Subject: FW: CM/48/201/DOC - Bairds Farm Shop, Field Rear of Crookthorn Lane, Climping, BN17 5SN

As long as revised drainage details can be provided this week that will be acceptable and the DOC application can remain live. The increase in height of the building would need to be considered as an NMA and would be acceptable provided the height does not increase by more than 30cm.

You haven't included a cap volume depth within your calculations. The 0.3 porosity does not extend to the height that is in the calculations, water is above the sub-base. Please apply an appropriate cap volume depth.

| DWG NO<br>003                                           | REVISION<br>P5 |                  |                                                        |                                                   |

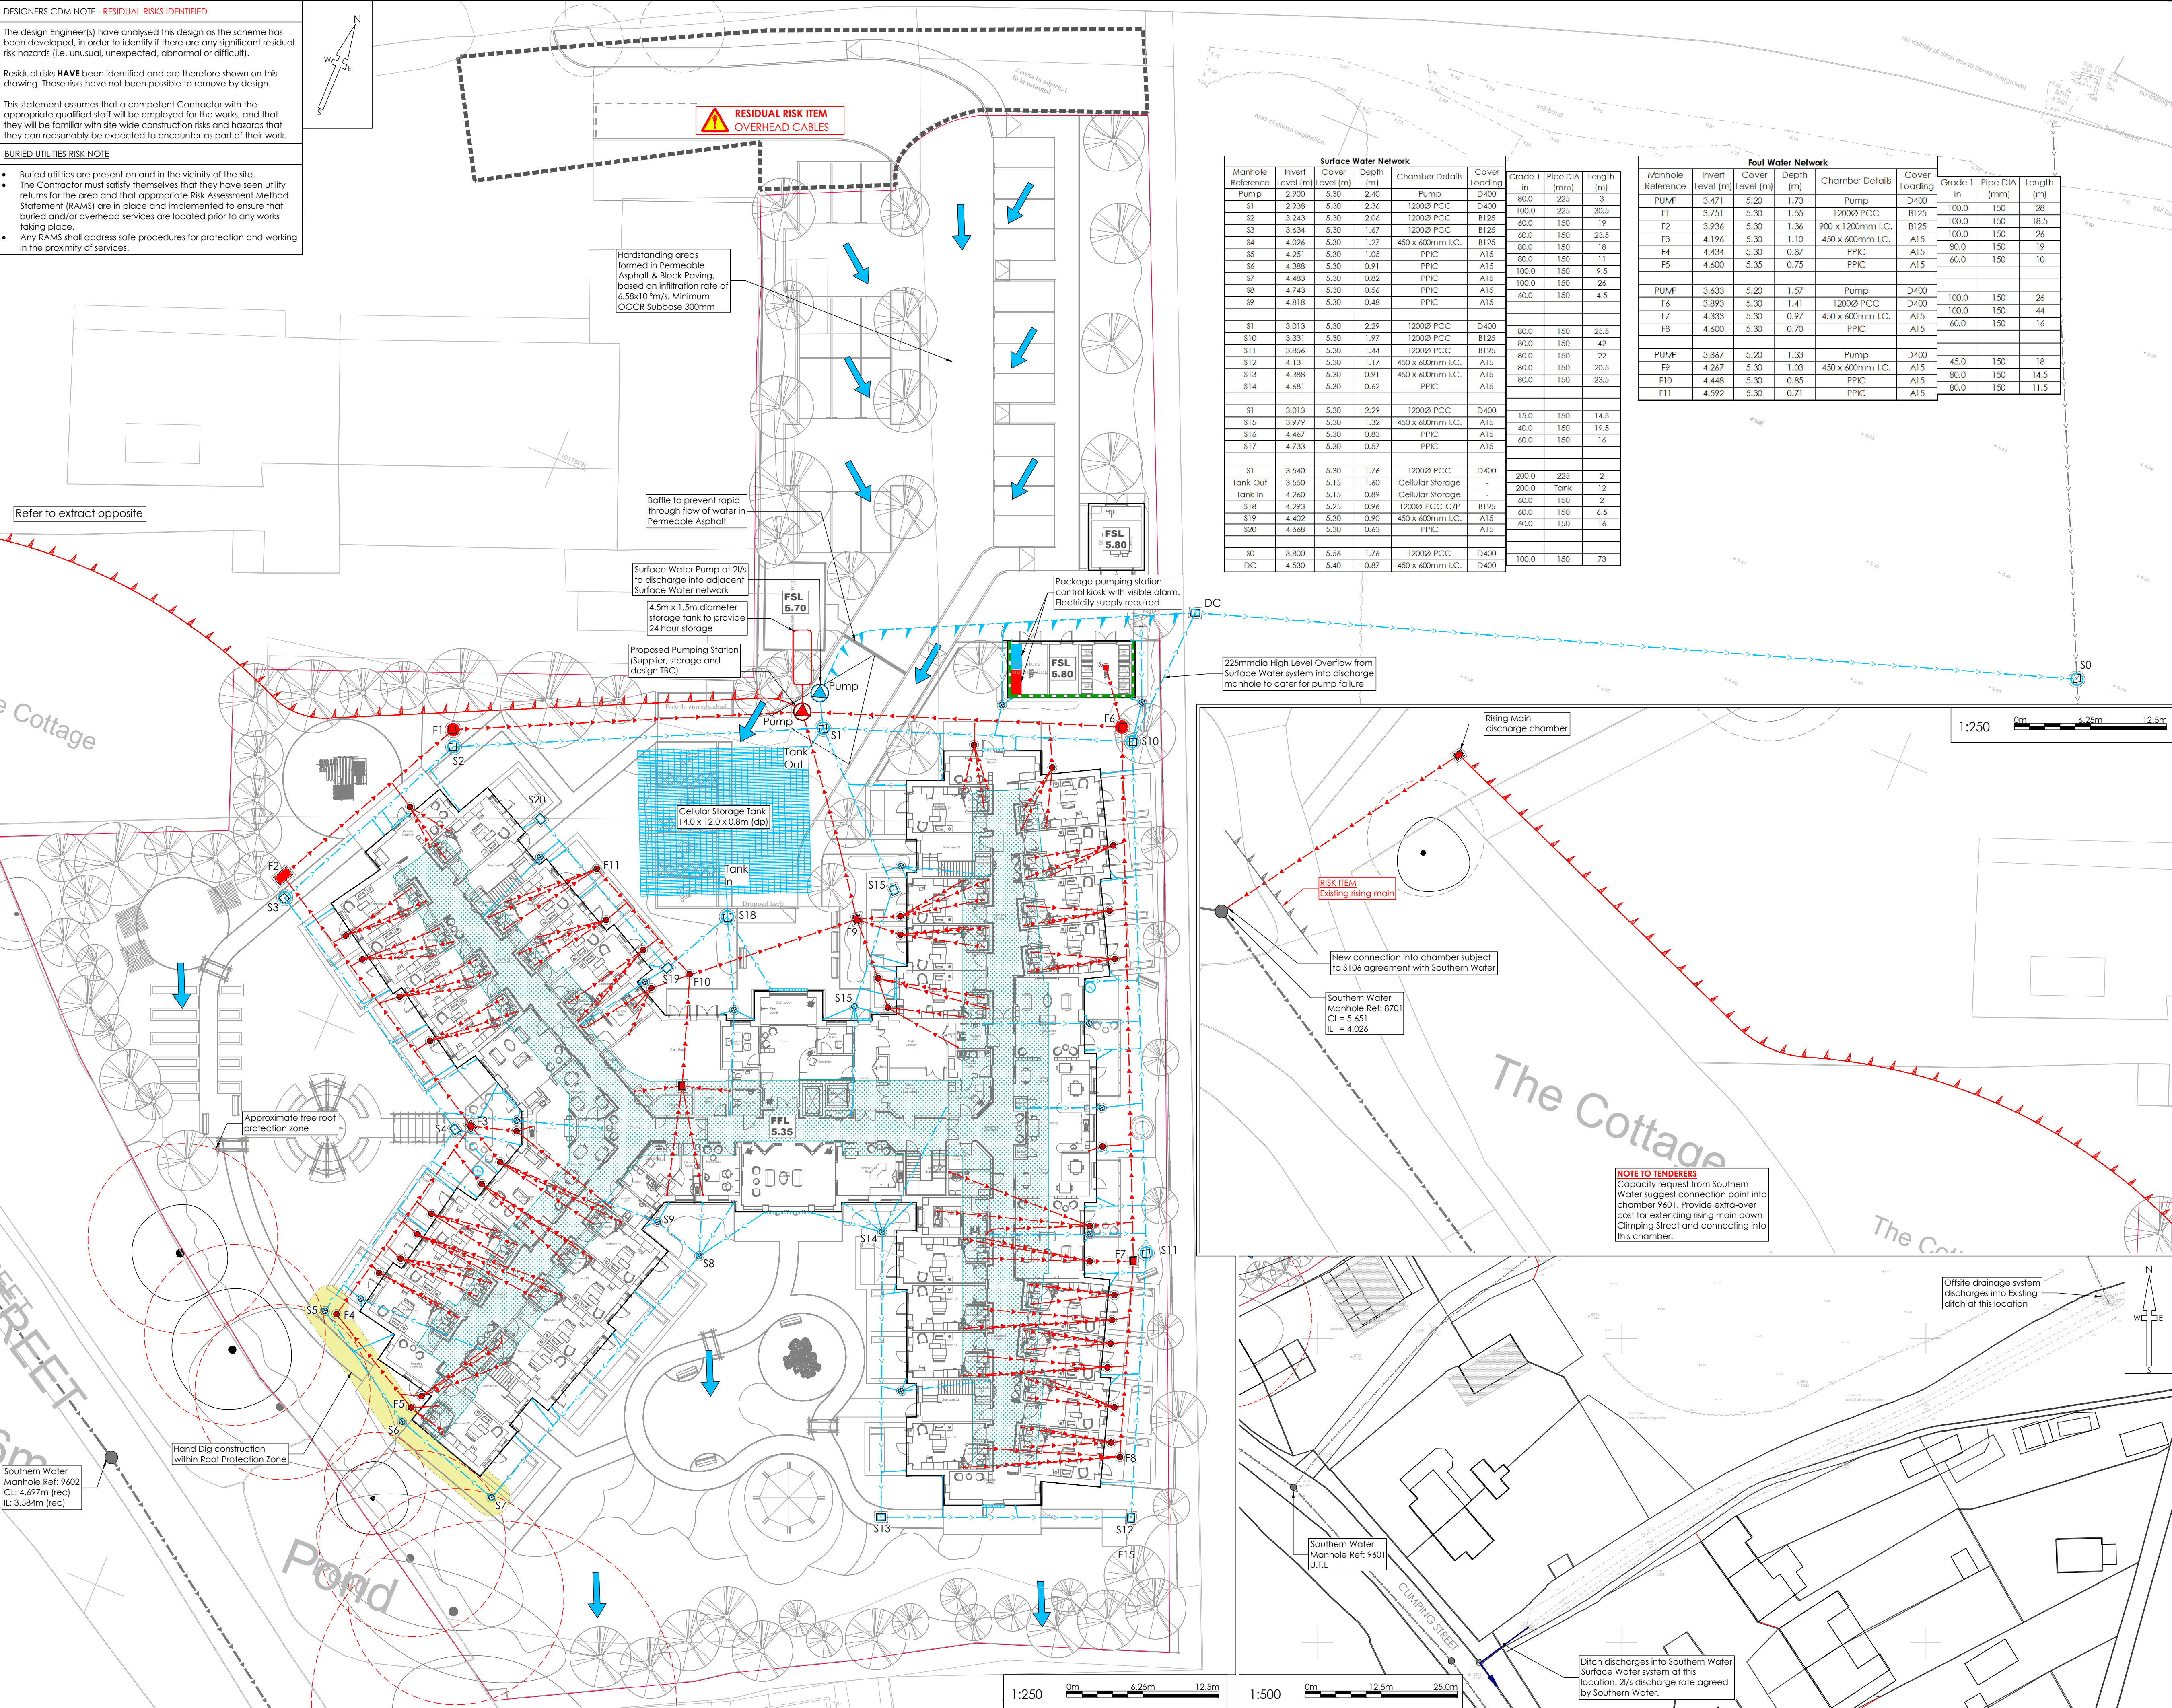
1. Please supply a figure showing the groundwater monitoring locations.
2. I note that Soakaway E has an invert at over 1m depth, based on the groundwater monitoring results near this location the design may need to be revised. (potentially link provided between permeable paving and this soakaway to ensure you have the required volume above peak groundwater level?)
3. Please supply a catchment plan- i.e. a layout which clearly shows the areas (and the size of these areas) that are draining to each soakaway.
4. Please label all pipes with diameters and falls.
5. We will require updated construction detail drawings and maintenance manual. Please include on the construction detail drawings the required crate type- or criteria they have to fulfil in terms of minimum acceptable cover depth.

1. We have added on the groundwater test locations and referred the depths back to existing ground levels to provide the levels of the groundwater. *Okay, point closed.*

2. Soakaway E does have a low invert however this is purely a result of having to provide additional cover over the crates to ensure that they will be able to take vehicle loadings. Lifting the crates higher will compromise their strength however we intend to link the permeable sub base with the soakaway to provide additional hydraulic storage to address this. We attach the calculations for the soakaway and soakaway plus permeable paving. *The peak groundwater level in this area is above the top of crates. It doesn't appear that you have sufficient volume in the permeable paving sub-base alone. I have calculated you have 22.68m³ volume available in the permeable paving sub-base, calculations indicate you require 55.6m³ of volume. Adequate storage must be provided above peak seasonal groundwater level, please demonstrate you can provide this. Please confirm how you intend to link the crate and permeable paving, is it via increasing the sub-base depth, if so then you may be providing the storage required.*

PERMEABLE ACCESS ROAD DETAIL

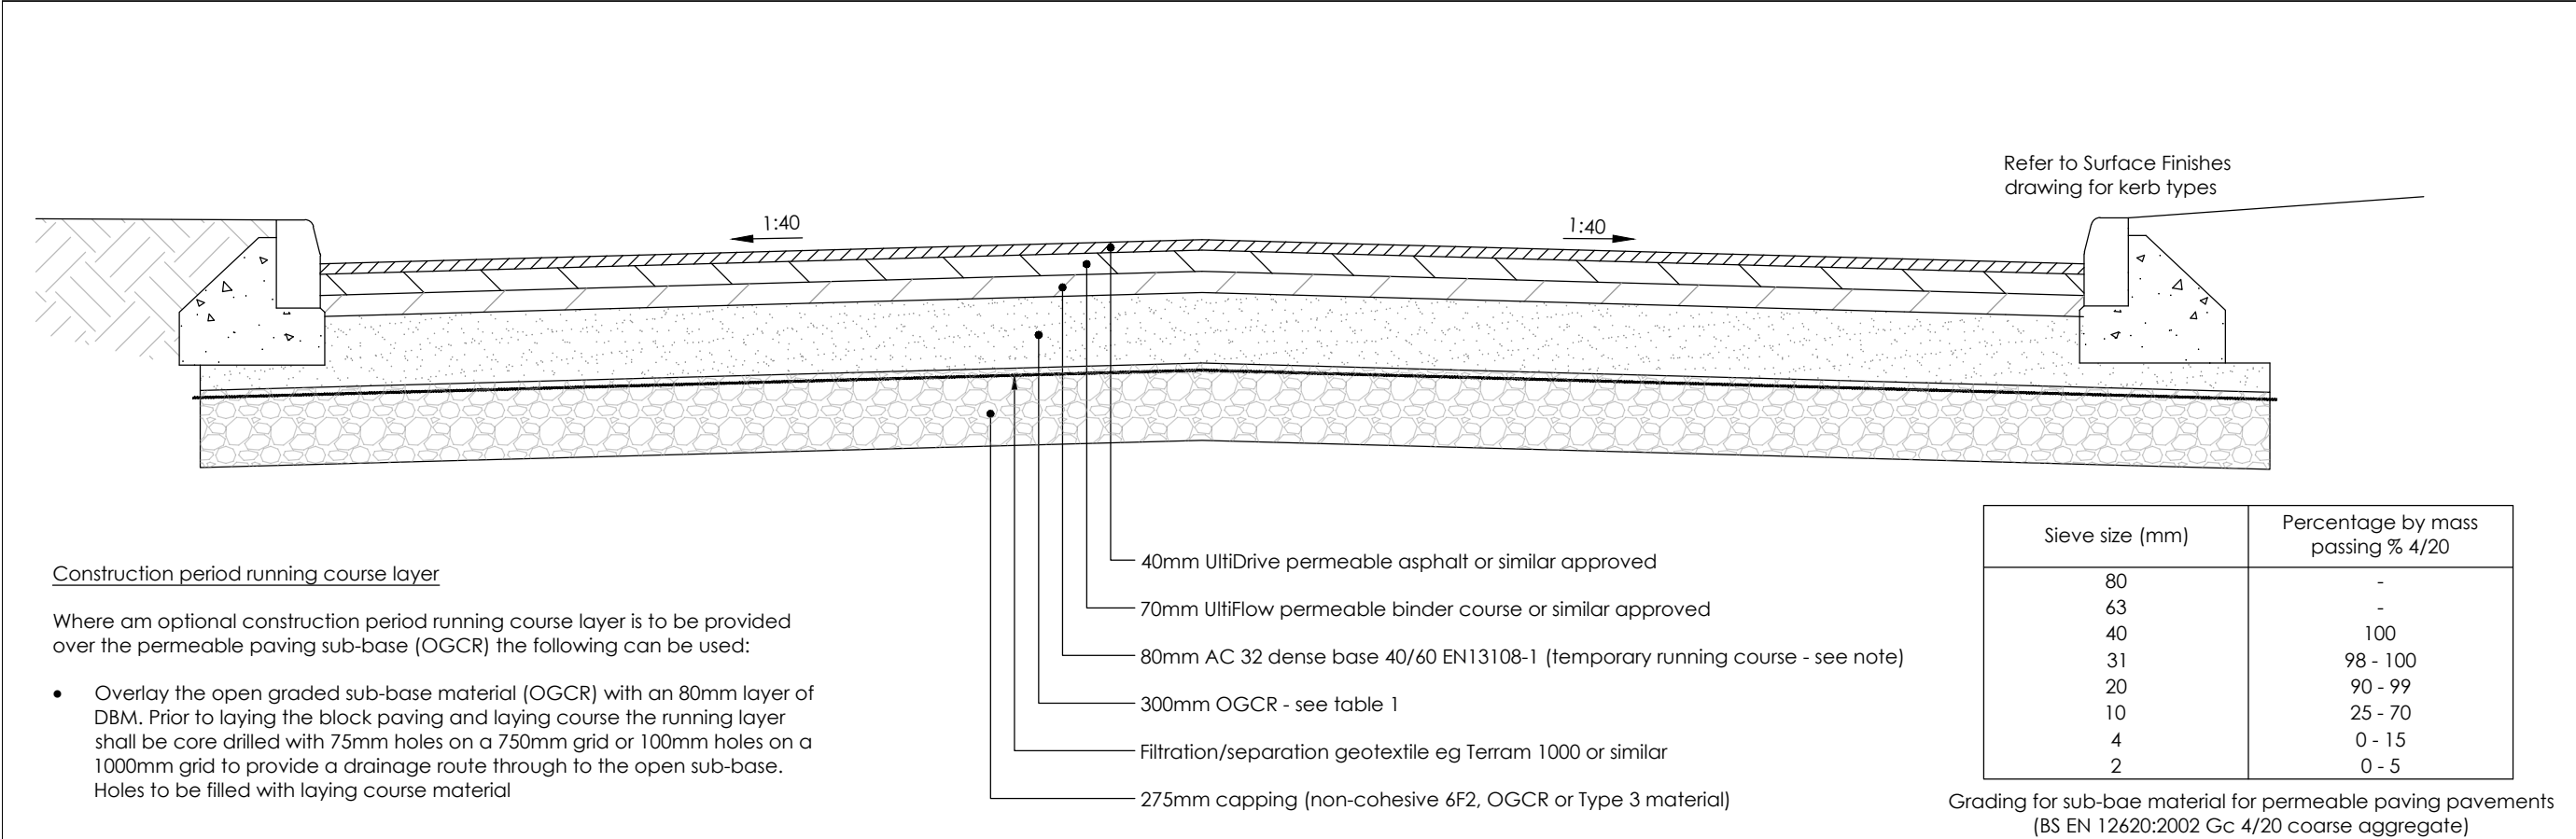
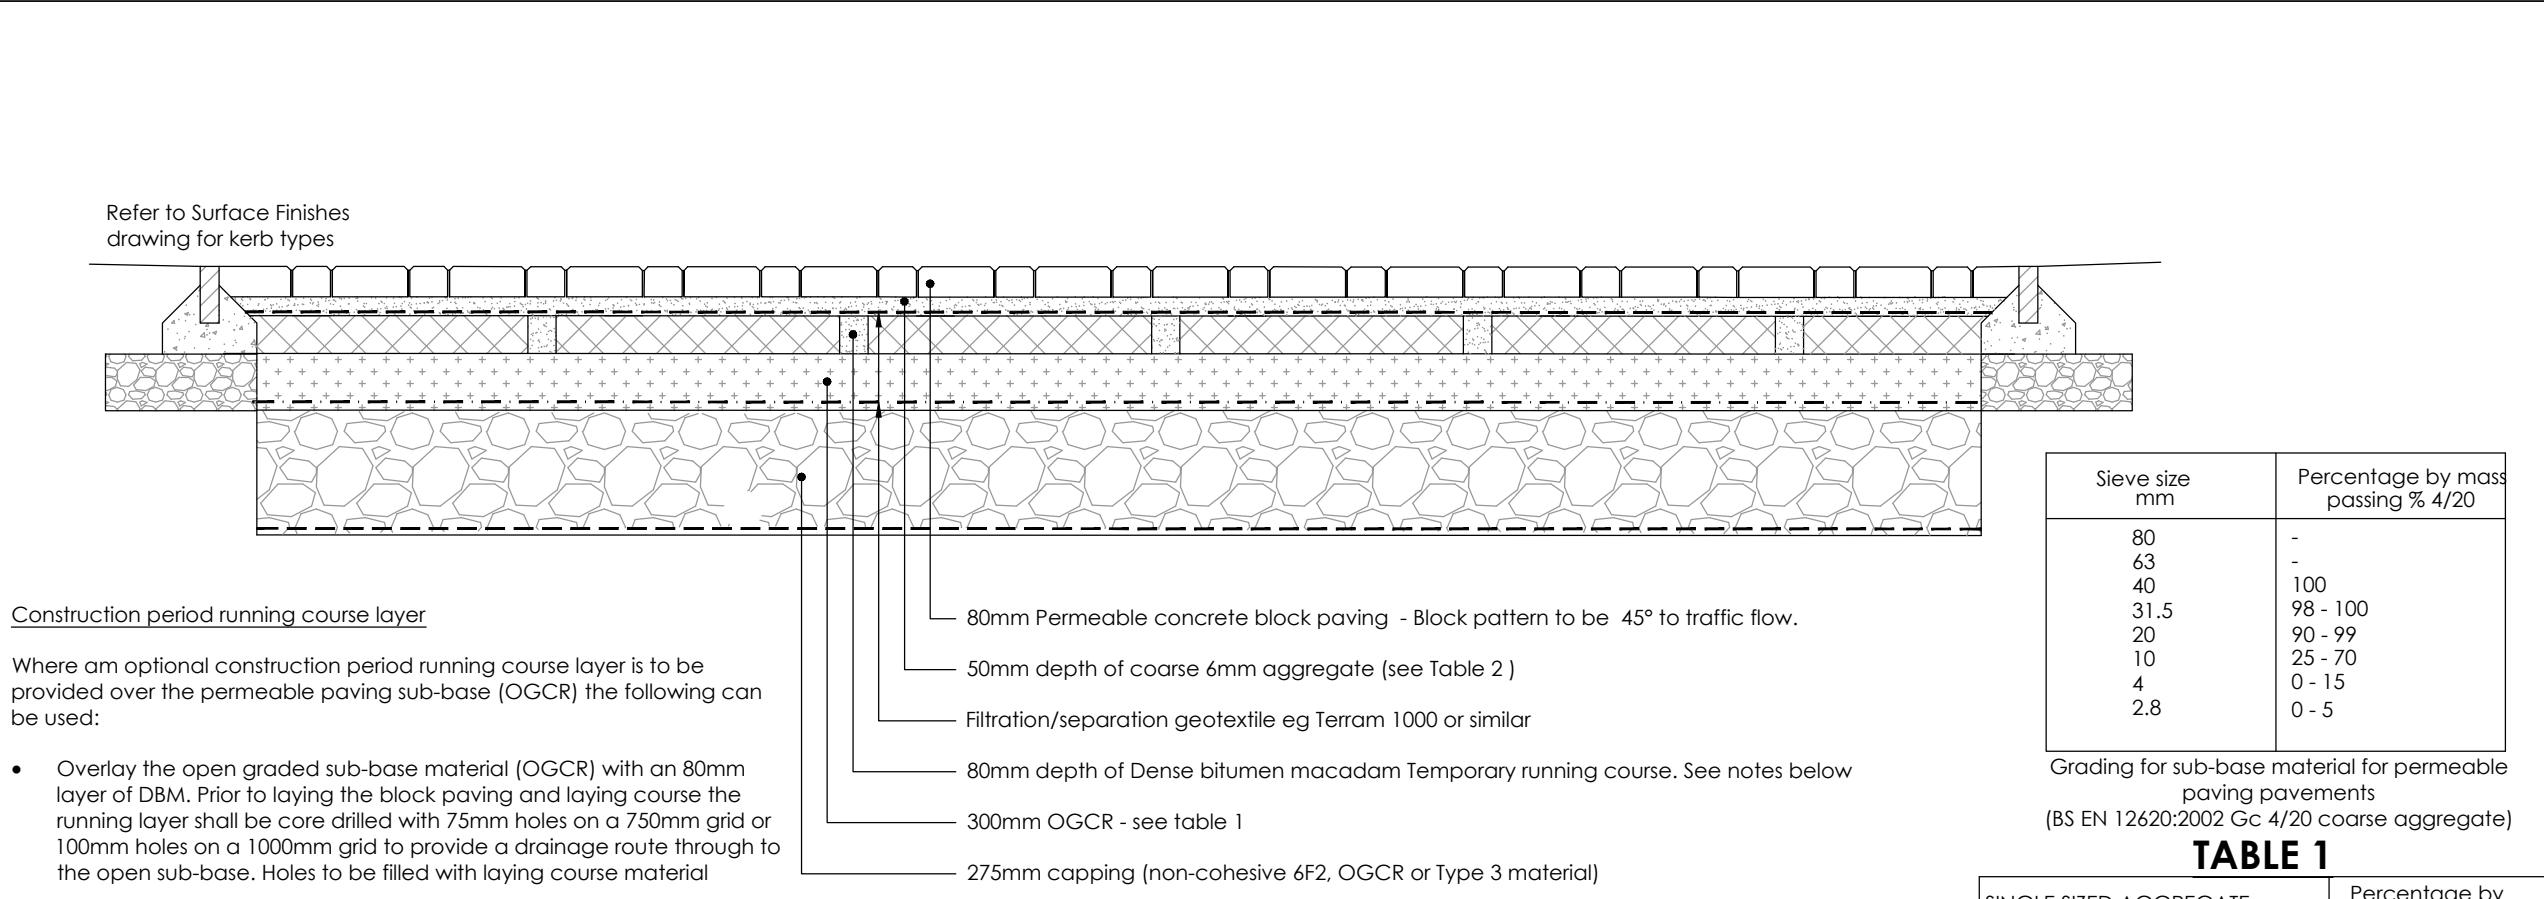
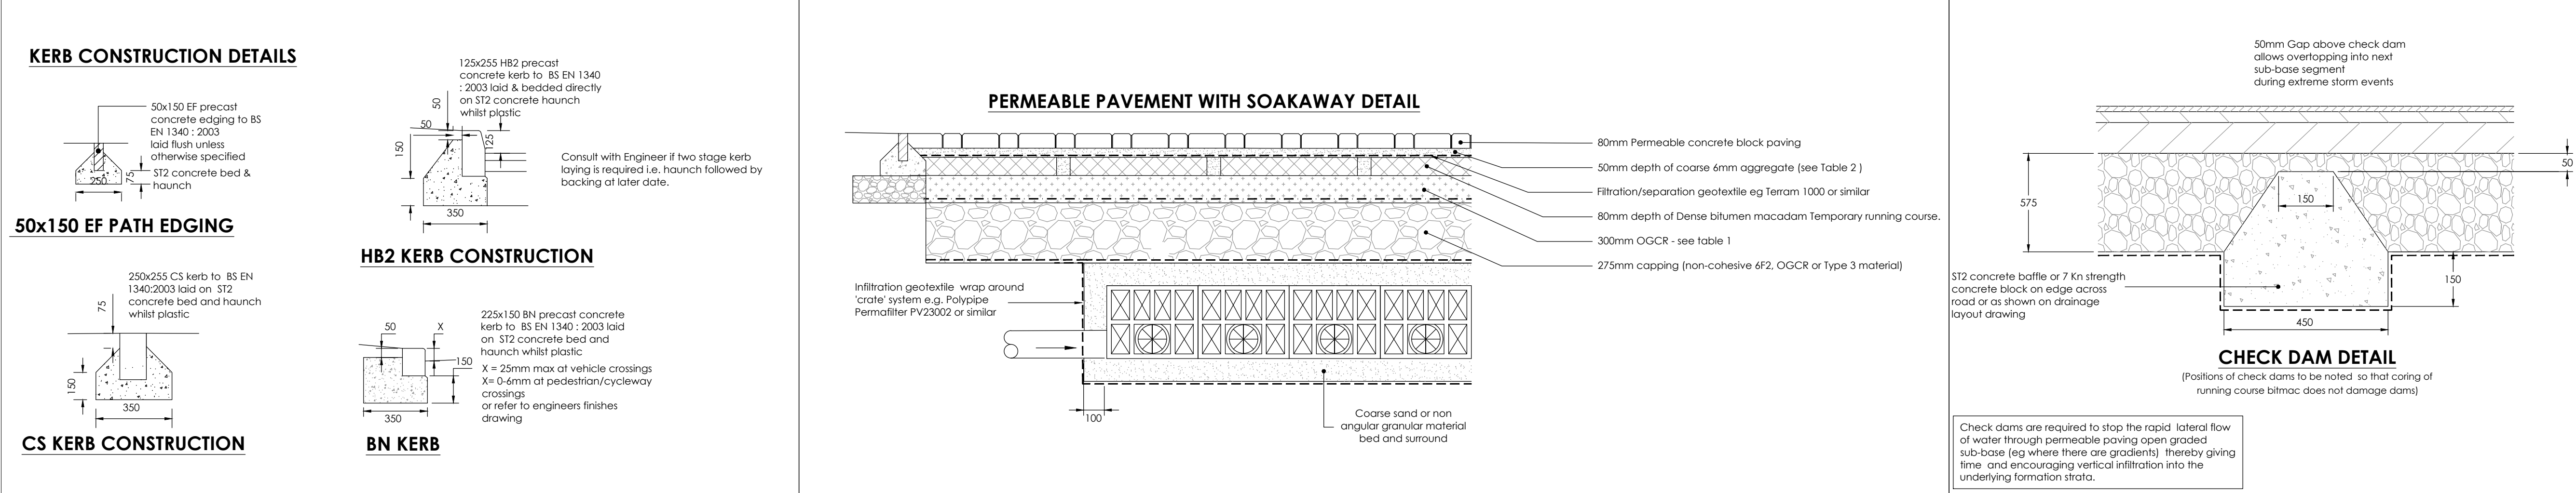
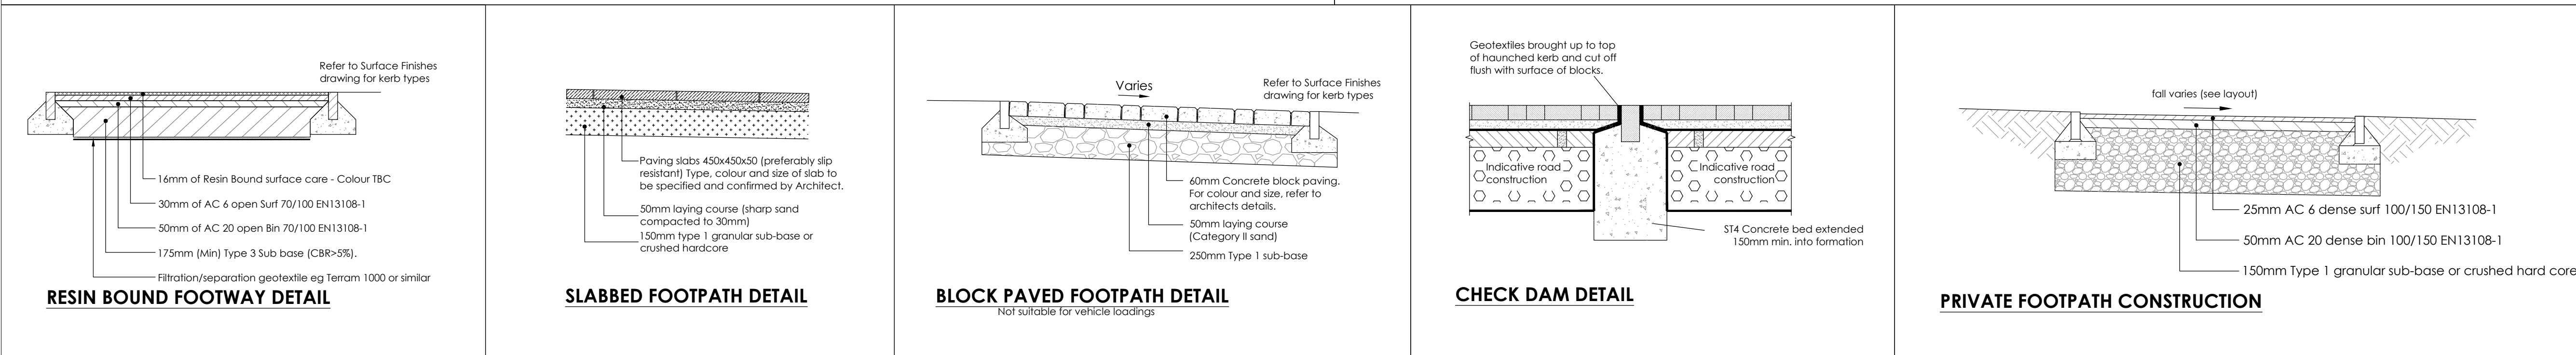
Please provide a construction detail drawing which clearly shows the linkage of the permeable paving sub-base with the crates here. I note you have also now introduced a baffle into the sub-base here, please provide a construction detail drawing of this.

Thanks for the email. Our intention is/was to extend the sub base of the permeable paving above soakaway E down to the top of the crate storage to interlink them hydraulically. We've expanded the note on the drawing to make this clearer.
